From: Havis, Sean <[REDACTED]>
Sent: 29 November 2021 09:56
To: Simon Davis
Cc: Sparkes, Jessica
Subject: RE: *EXTERNAL: Response To Application Number Y/156/21/DOC at Land East of Drove Lane Yapton BN18 0EB
Attachments: BH-H8277-09c-SIT-01_Site Execution Plan_B.pdf

GENERAL ARRANGEMENT PLAN

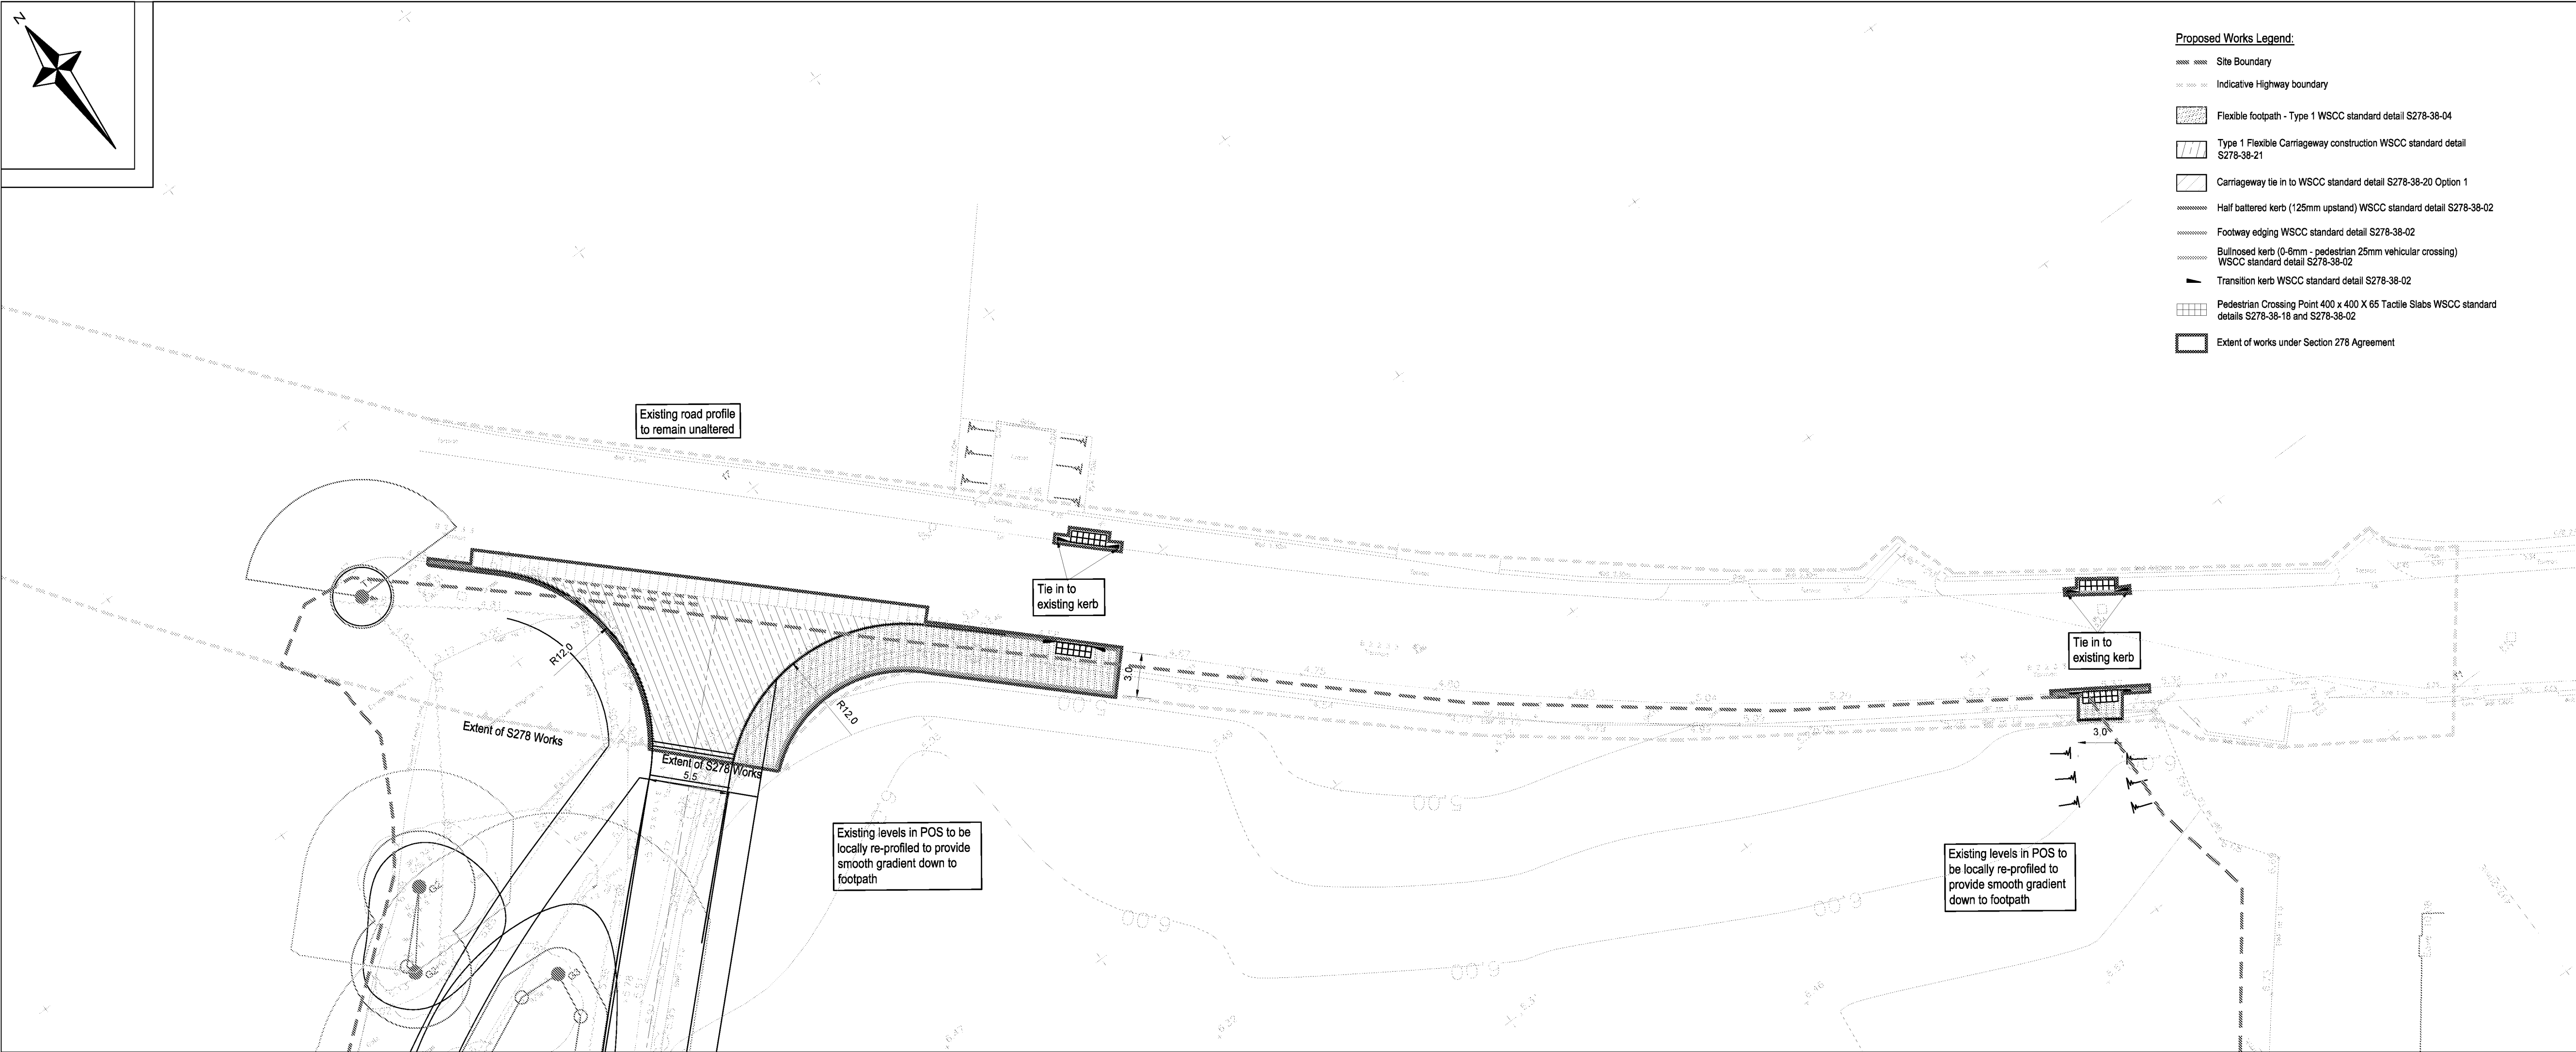
I will review with Claire as to whether we can agree it. However, can you advise what the black hashed lines are on the phasing plan and why not all areas have a date on them.

The black hashed lines simply delineate the areas that are our Barratt Housetypes with those outside being our David Wilson housetypes. This is principally for internal use.

Please find updated Phasing Plan showing the whole site. Please note that the dates are subject to change depending on external circumstances (i.e. snow like today!)
